From: Anita Gardner
Sent: 18 December 2017 10:41
To: Planning.Responses
Subject: FW: FG/151/17/DOC - Discharge of condition 3 surface water drainage Ferring Country Centre, Ferring
Importance: High

From: [REDACTED]
Sent: 15 December 2017 16:43
To: Anita Gardner
Cc: Phil Acton
Subject: FG/151/17/DOC - Discharge of condition 3 surface water drainage Ferring Country Centre, Ferring
Importance: High

DRAWING TITLE:
PLANNING
PROPOSED SITE PLAN, SECTIONS & DETAIL.

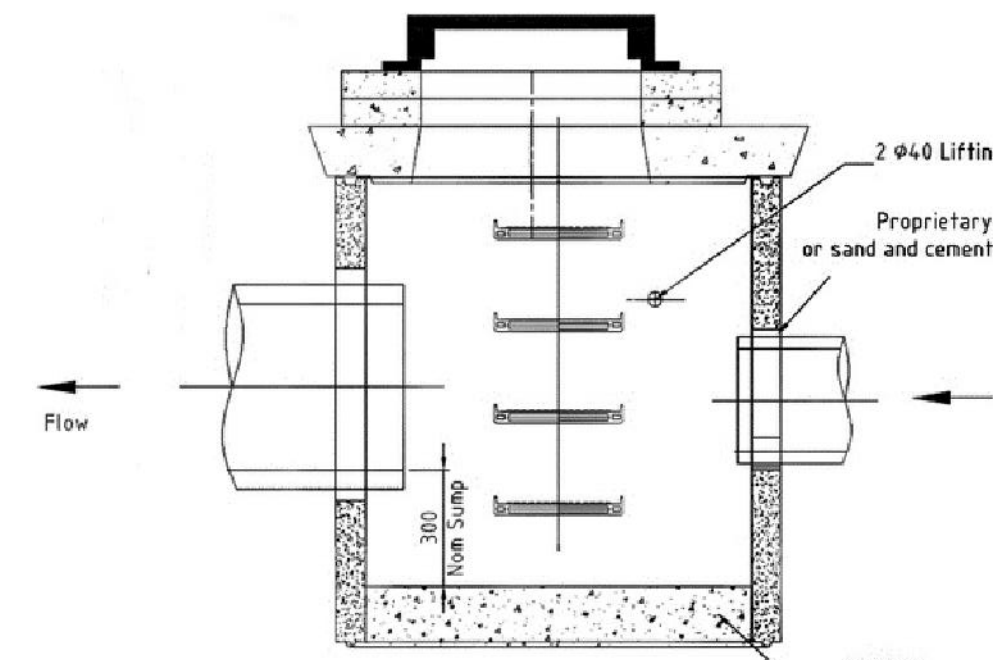
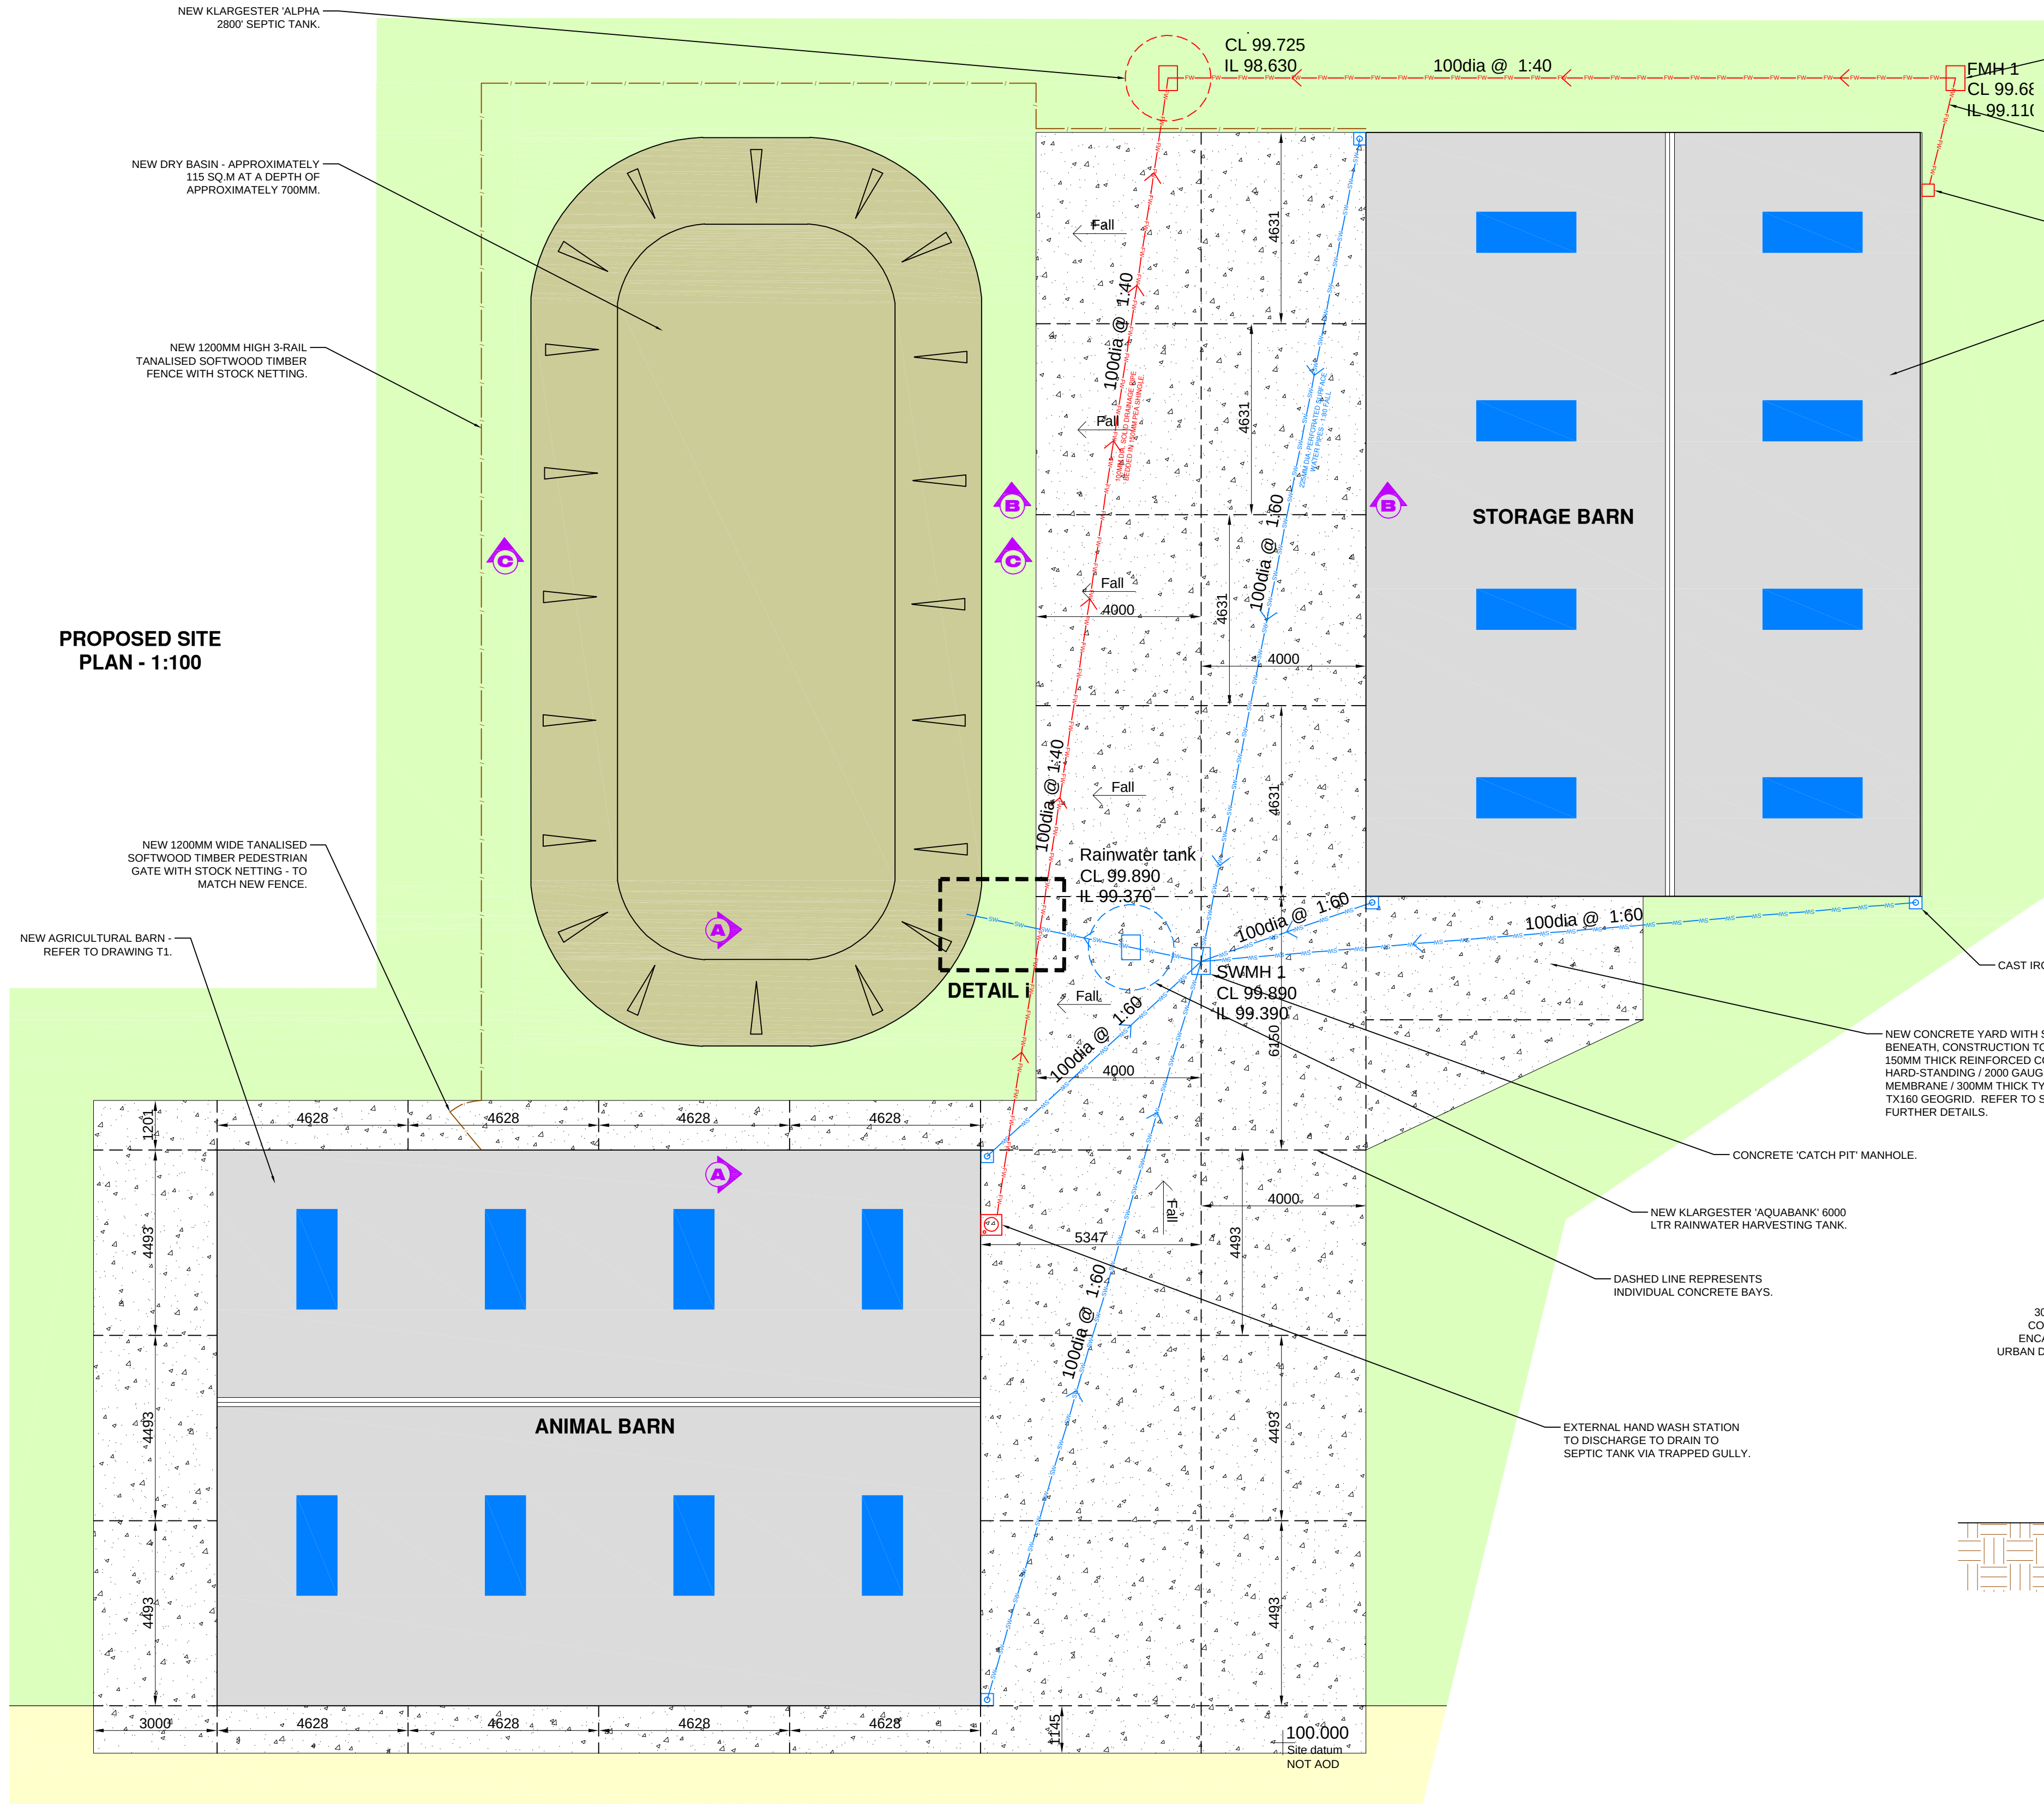
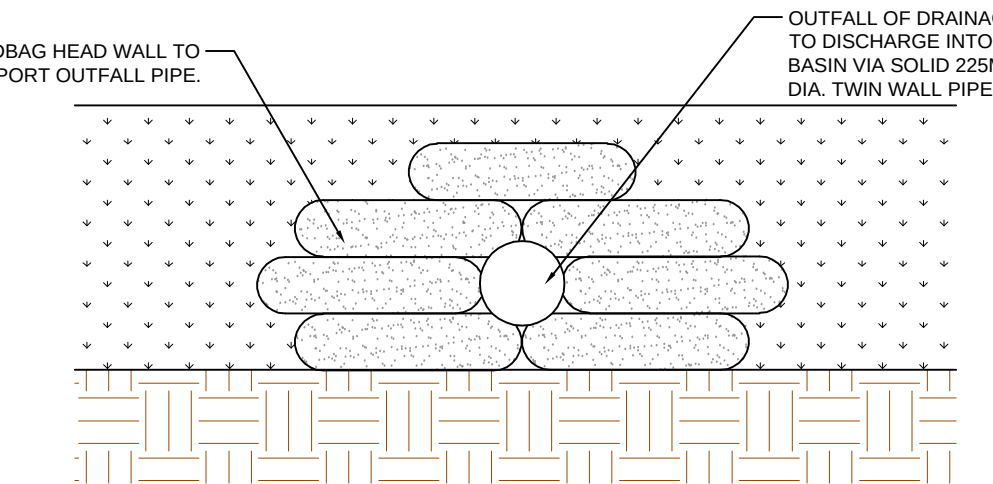
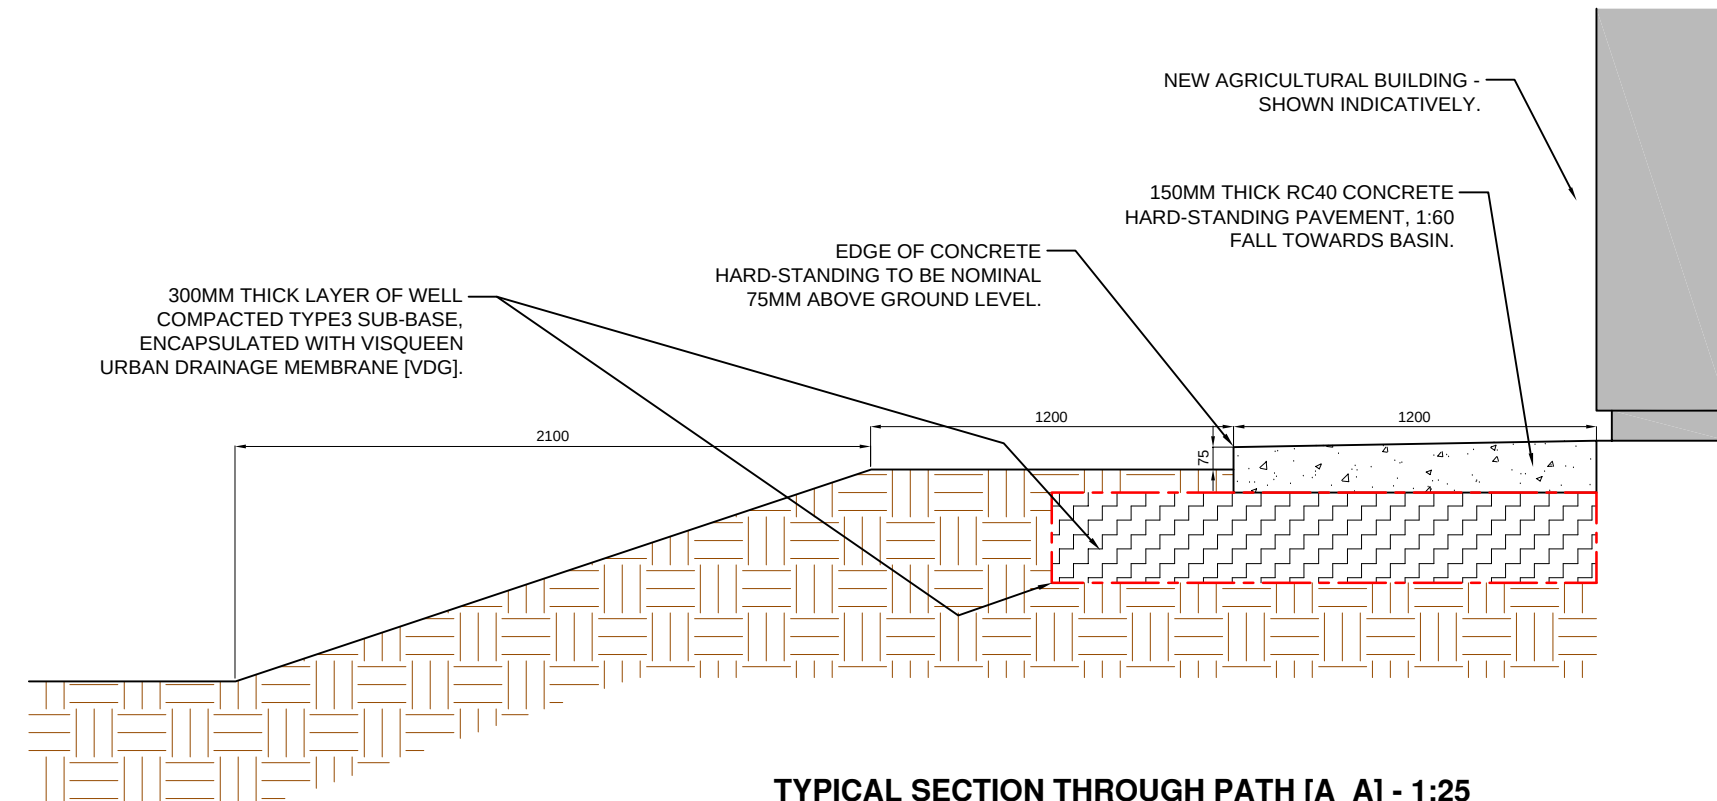
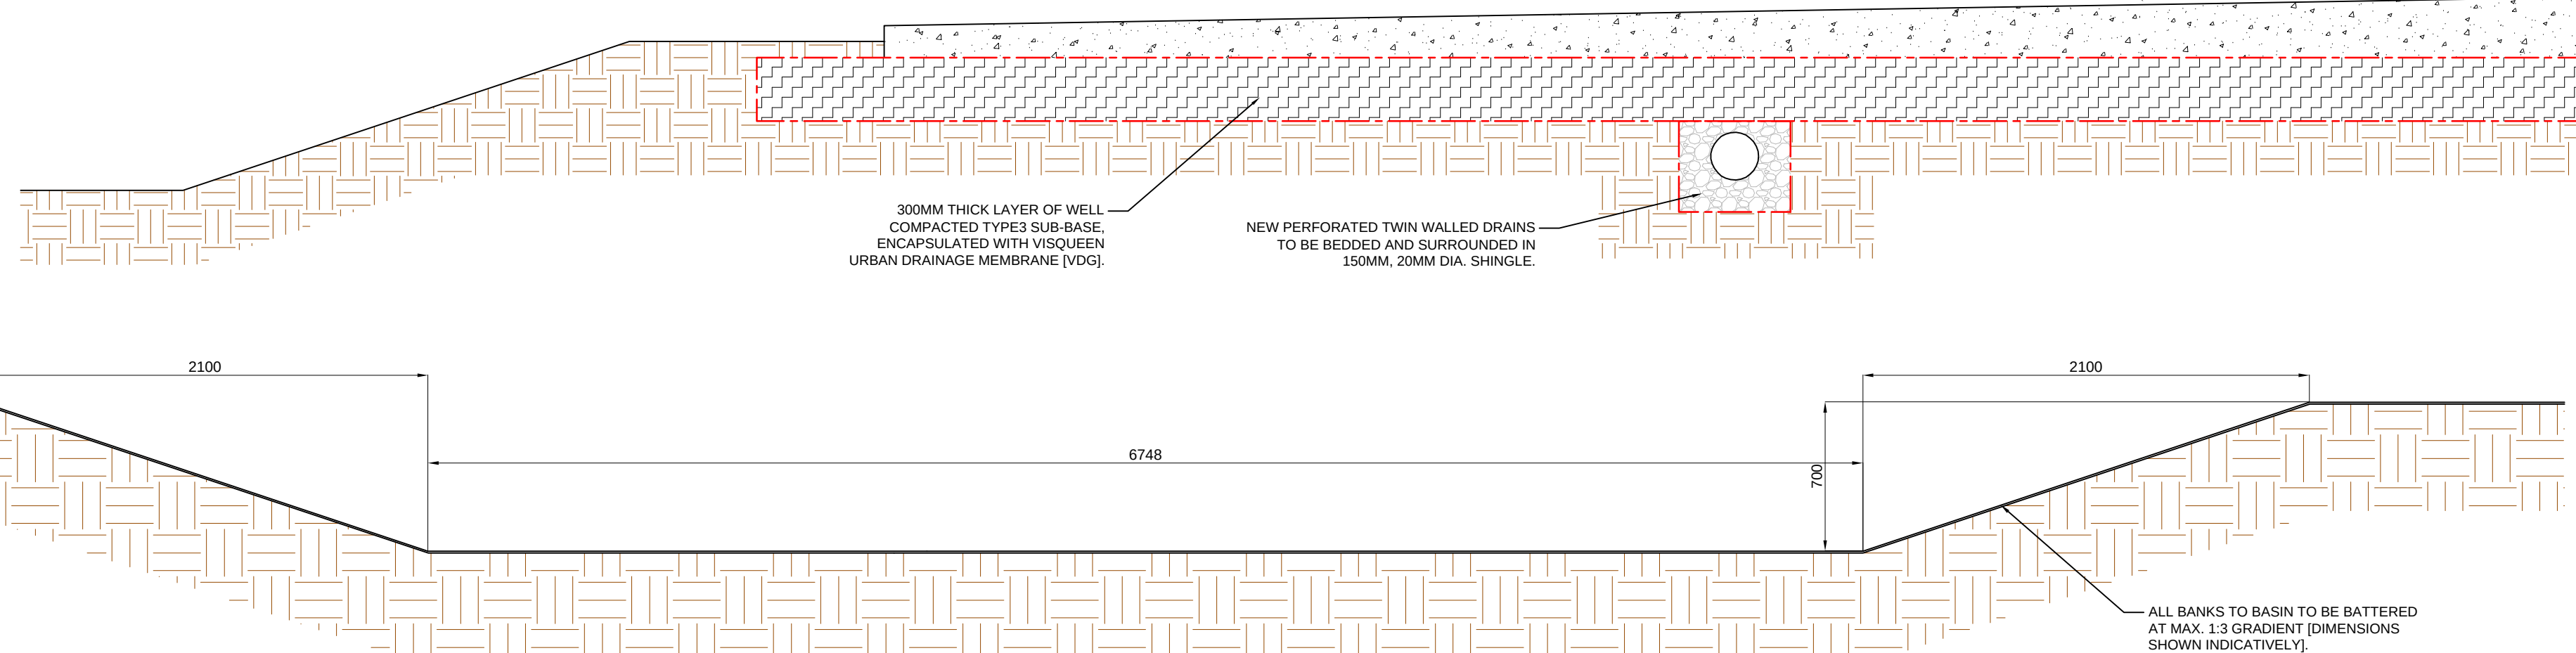
3. Specify outfall invert level to basin and the relative basin base/formation level. This level has been revised - see revised drawing PL2 rev B.
4. Is the basin to be grassed? Specify. Yes -- 'General Purpose Meadow Mix'. See revised drawing PL2 rev B / PL3.

5. Specify pipe gradients (and pipe diameter between SWMH1 and rainwater tank) downstream of manhole SWMH1 (ensuring that the 225mm pipe is laid soffit to soffit with the upstream 100mm pipes. See revised drawing PL2 rev B / PL3.

6. It is not clear as to the routing of the 225mm perforated pipes beneath the type 3 plate soakaway. Please indicate, including levels/gradients. A note in this respect is shown just west of the storage barn but doesn't make anything clear. See drawing PL2 rev B / PL3 – site datum is +100.000, concrete surface falls 1:100 towards the basin. I have made some amendments to the annotation so please study the drawings again. The pipes with the plate soakaway are 100mm dia. The only 225mm pipes are from the catch-pit to the basin, which are solid.
7. Due to the proposed depth of the catchpit manhole, it will be difficult to construct a concrete ring manhole. I would suggest that an engineering brick manhole is utilised. Please provide full details, ensuring that pipes are indicated as laid soffit to soffit. Accepted – brick catchpit shown indicatively on drawing PL3.
